From: Brendan Hoskins <BHoskins@jbaurban.com.au>
Sent: Tuesday, 9 February 2016 3:17 PM
To: Matthew Rosel
Subject: RE: SSD 6010 MOD1 and SSD 7133 - further information request
Attachments: 15028_DA2100[05].pdf

From: Matthew.Rosel@planning.nsw.gov.au [mailto:Matthew.Rosel@planning.nsw.gov.au]
Sent: Friday, 5 February 2016 4:24 PM
To: Brendan Hoskins
Subject: SSD 6010 MOD1 and SSD 7133 - further information request

I am finalising my assessment of the above applications and there are a number of points of further information I require before I can complete the assessment, refer below:

Drawing Title
GROUND FLOOR AND LEVEL 1 PLAN

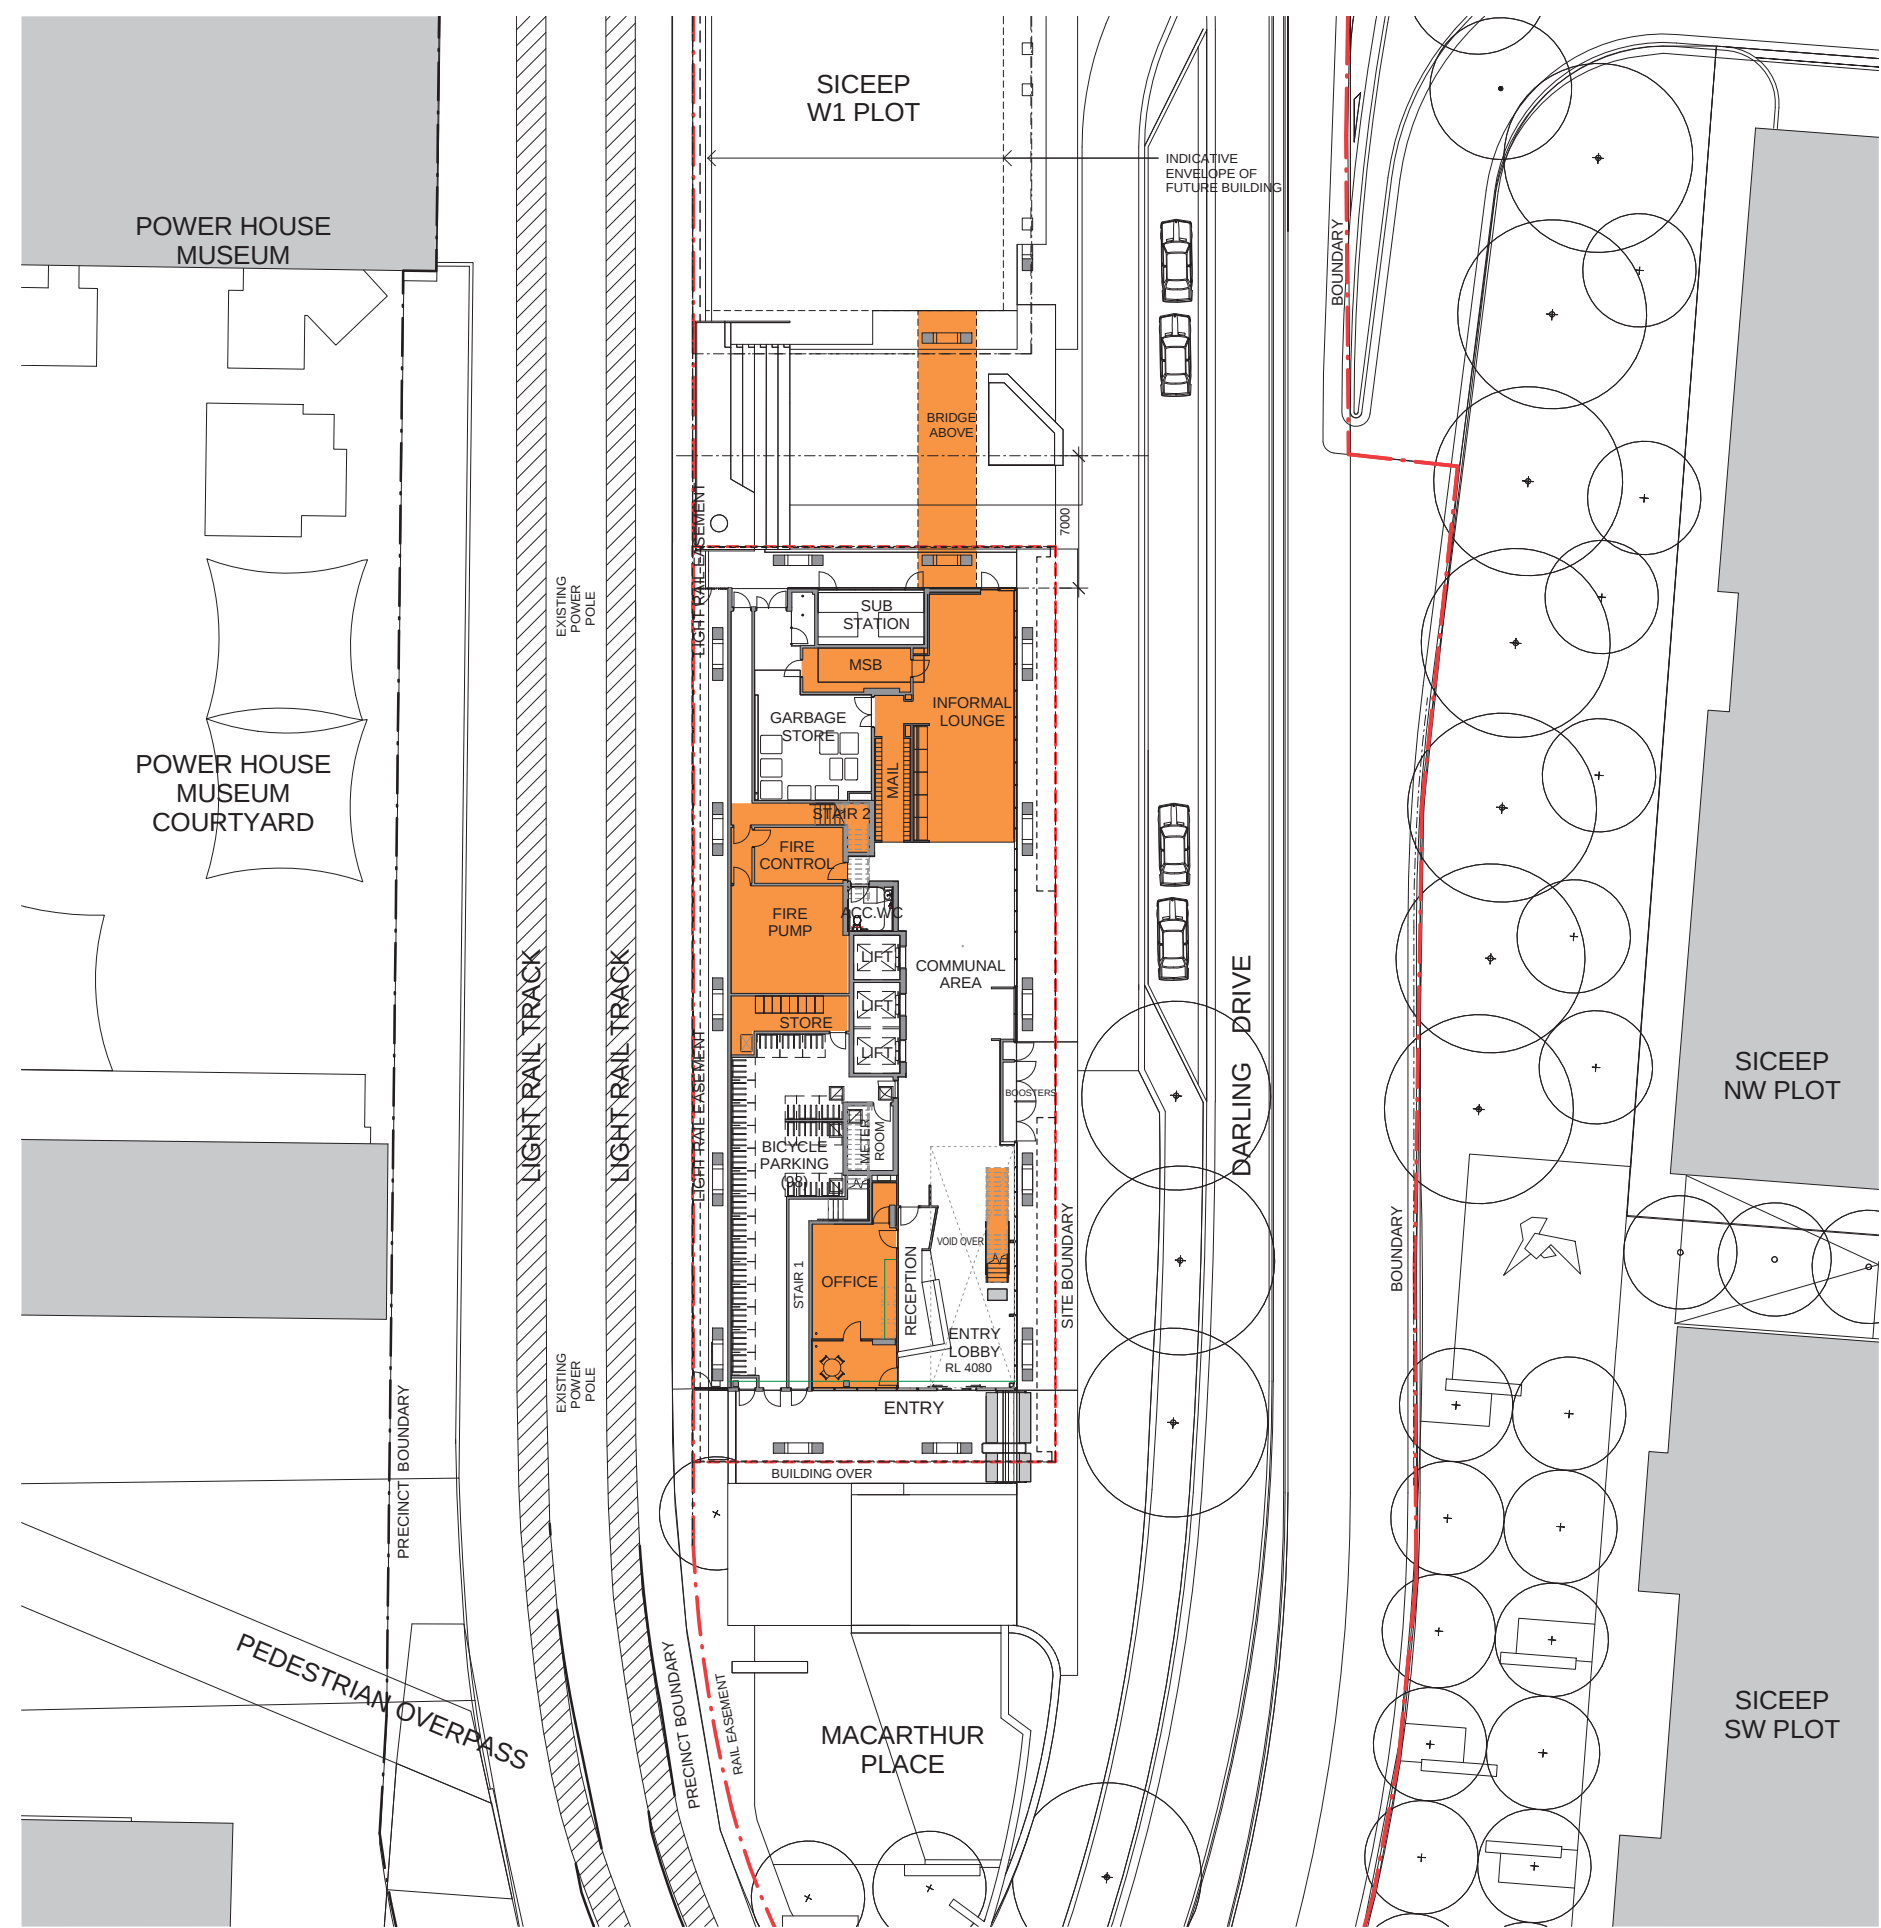
4. updated drawing DA2100 indicates that 114 bicycle parking spaces are provided within the internal bicycle store at ground level. This is contrary to the discussion at section 2.4.2 of the RtS. Can you confirm whether 90 or 114 spaces are proposed;

The number of bicycle parking spaces provided is unchanged from the exhibited proposal, with 90 spaces still proposed. The incorrect annotation on Drawing A2100_05 has been updated (see attached).

Drawing Title
BRIDGE LINK DETAILS

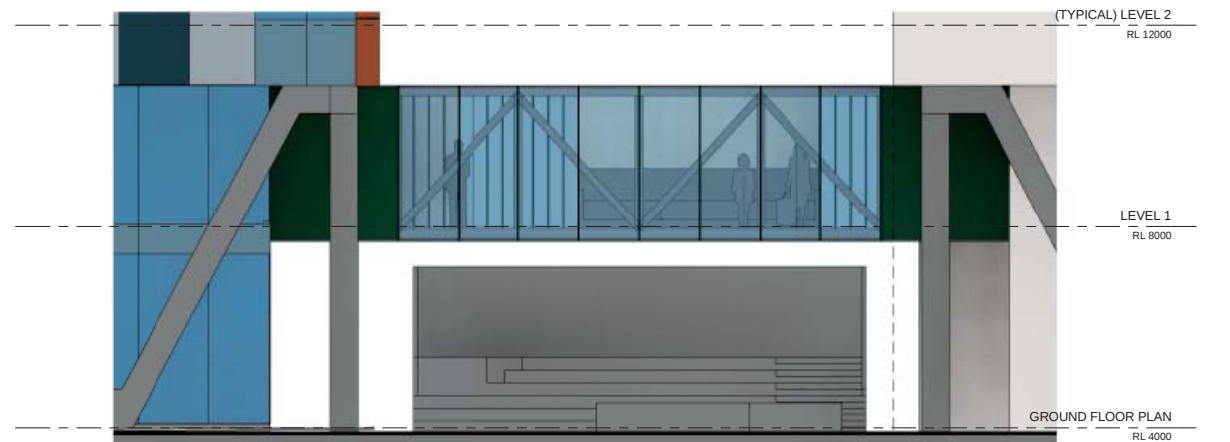
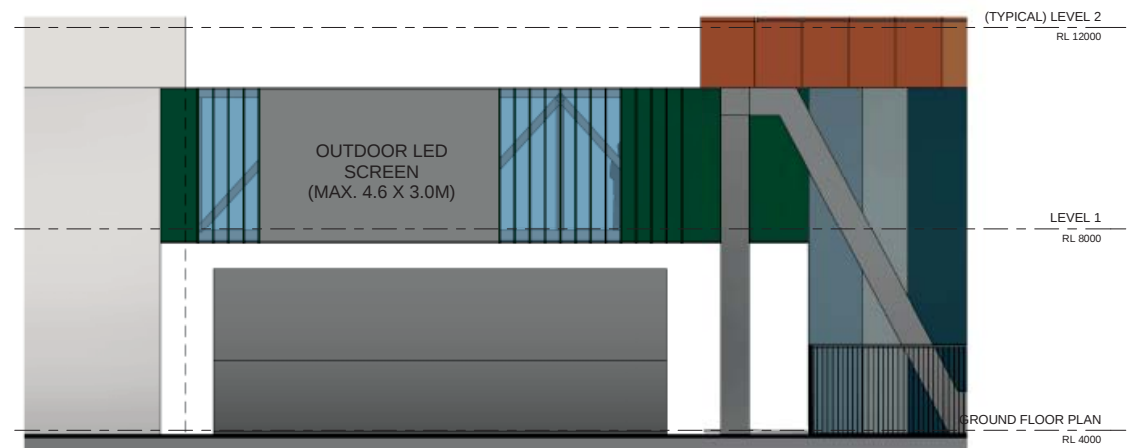
5. can you confirm the dimensions of the LED screen;

The final size of the LED screen will be determined during design development with the supplier. A maximum extent of 4.6M x 3.0M is sought for the LED screen.
